MECKLENBURG COUNTY  
Park and Recreation Department

MEMORANDUM

**DATE:** February 2, 2021

**RE:** Rezoning Petition #2020-068 - Hedgemore

SCHEMATIC SITE PLAN
PETITION # 2020-068
FOR
HEDGEAMORE - MONTFORD PARK
CHARLOTTE, NORTH CAROLINA 28209

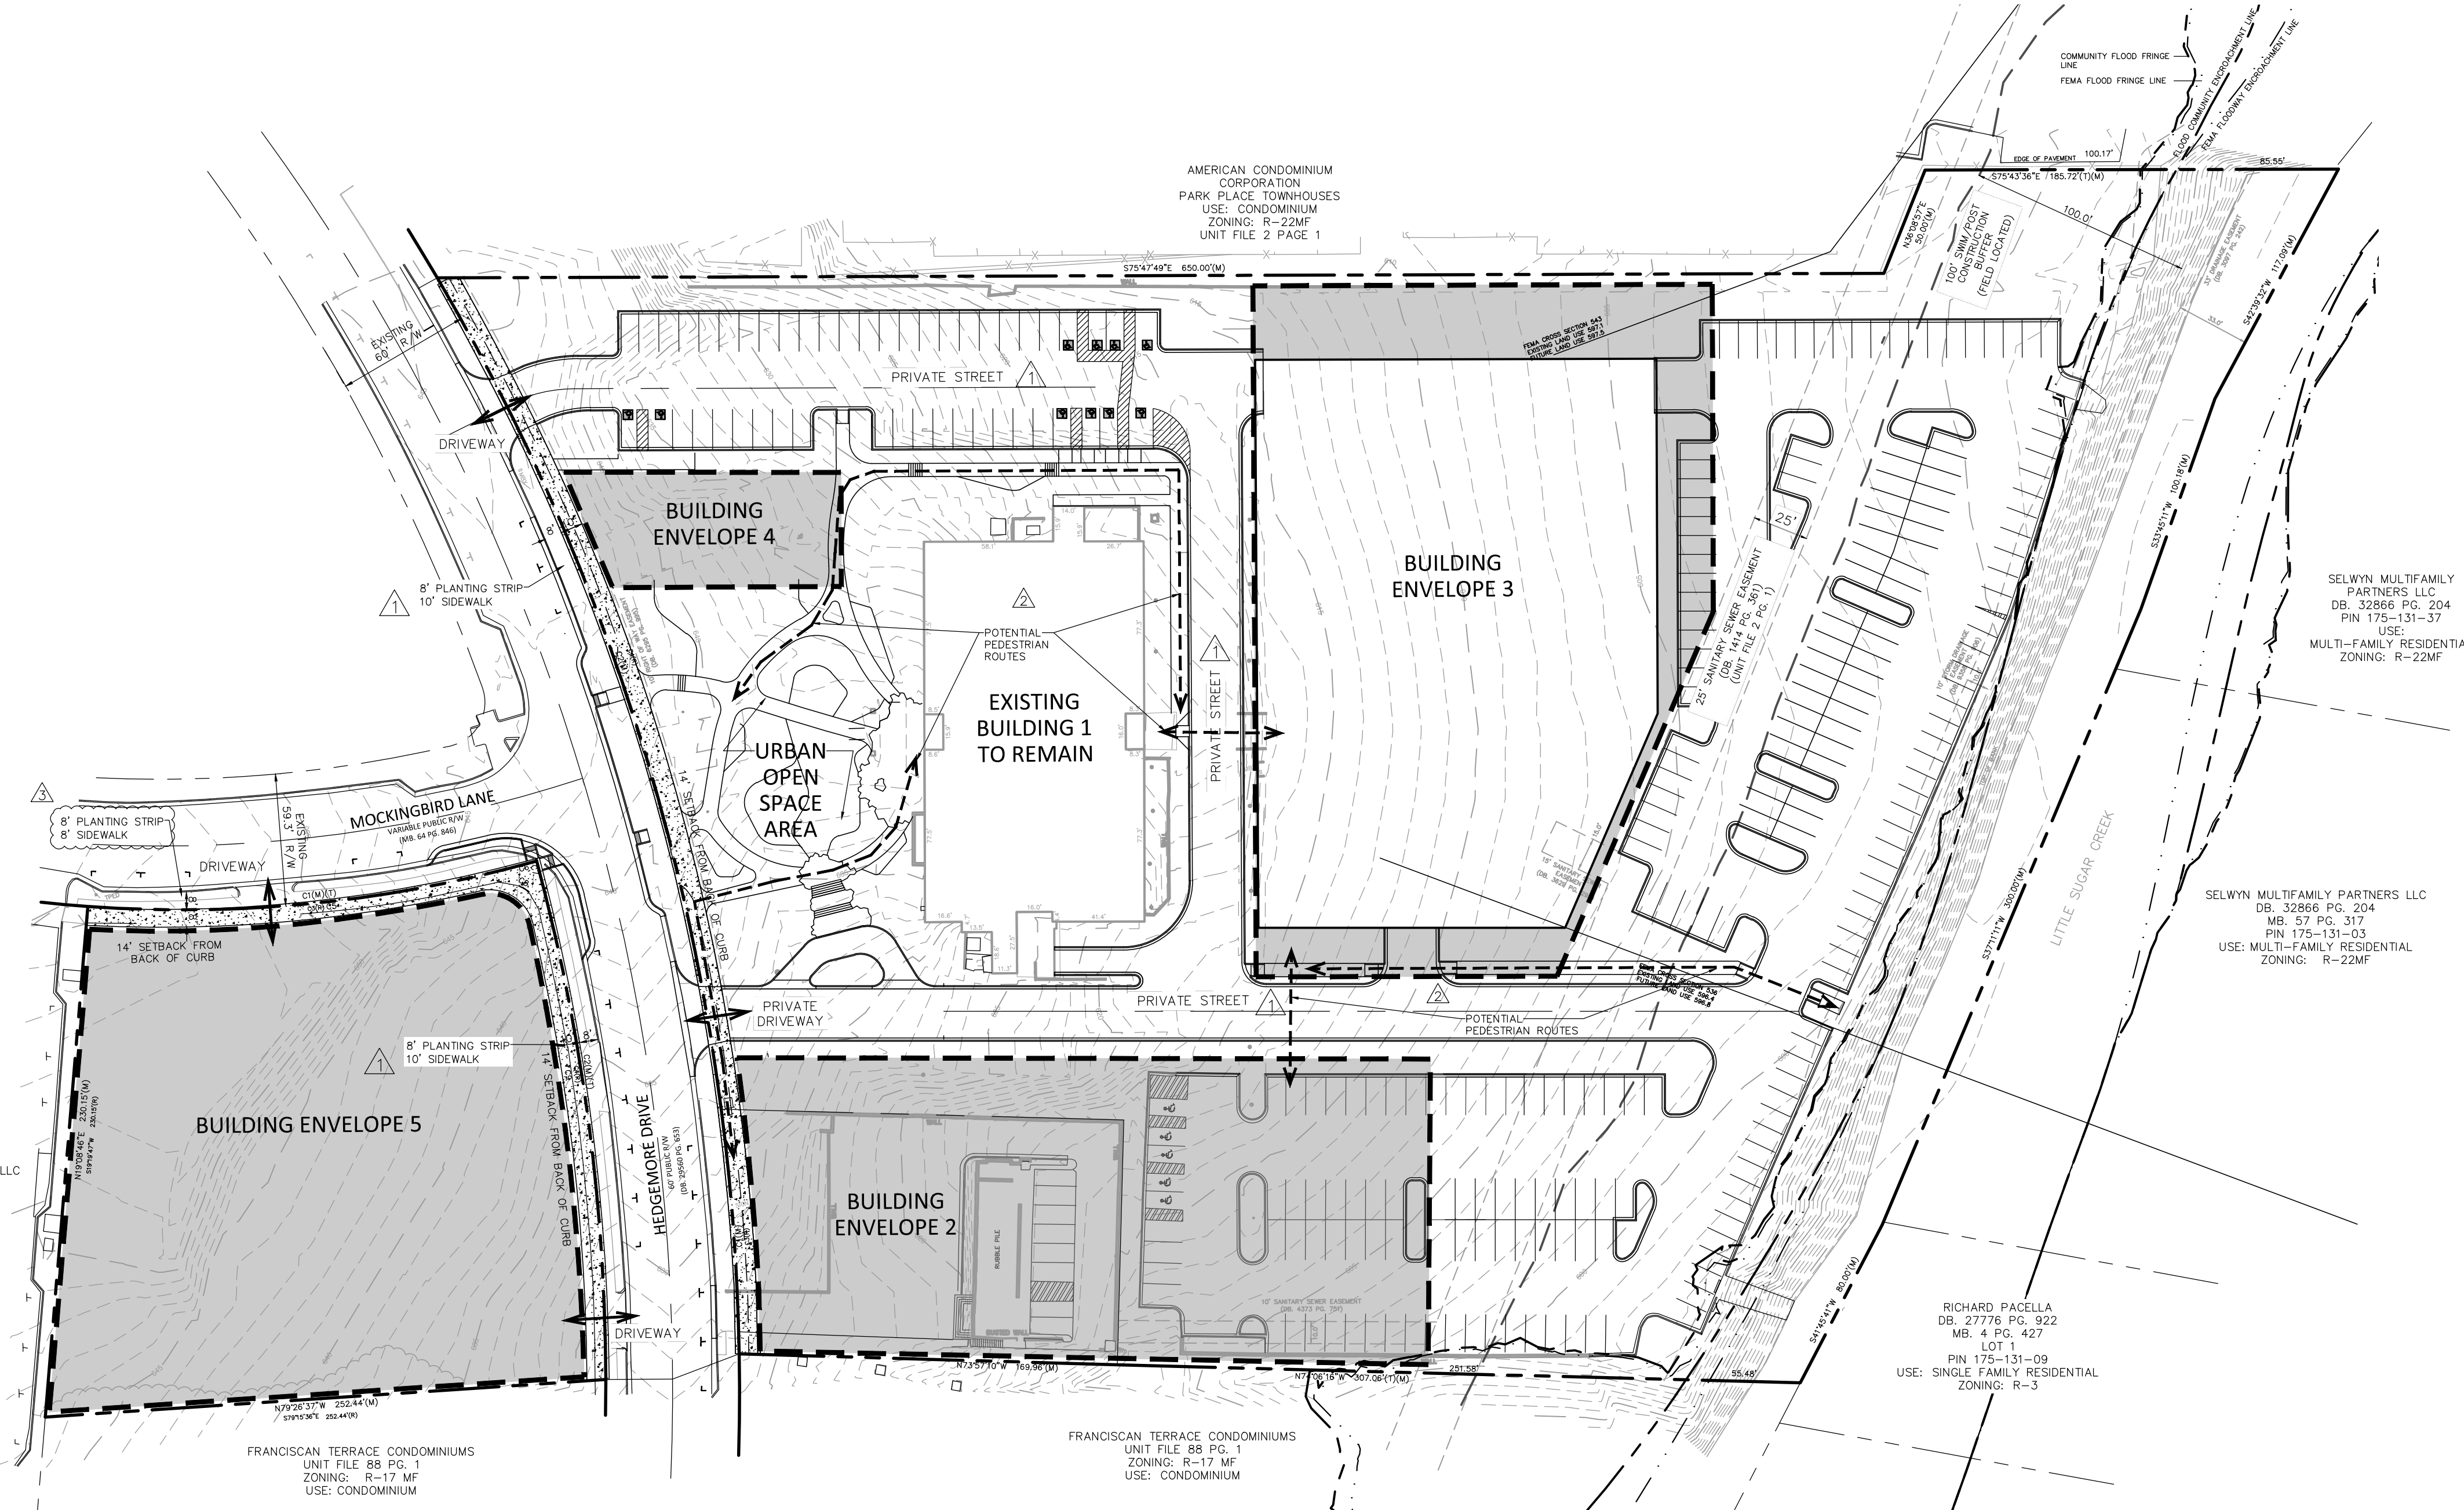
MCPR requests the petitioner dedicating and conveying to Mecklenburg County the 100' SWIM Buffer of Little Sugar Creek. This parcel is on the MCPR Greenway and Charlotte Cross Charlotte Trail Master Plan.
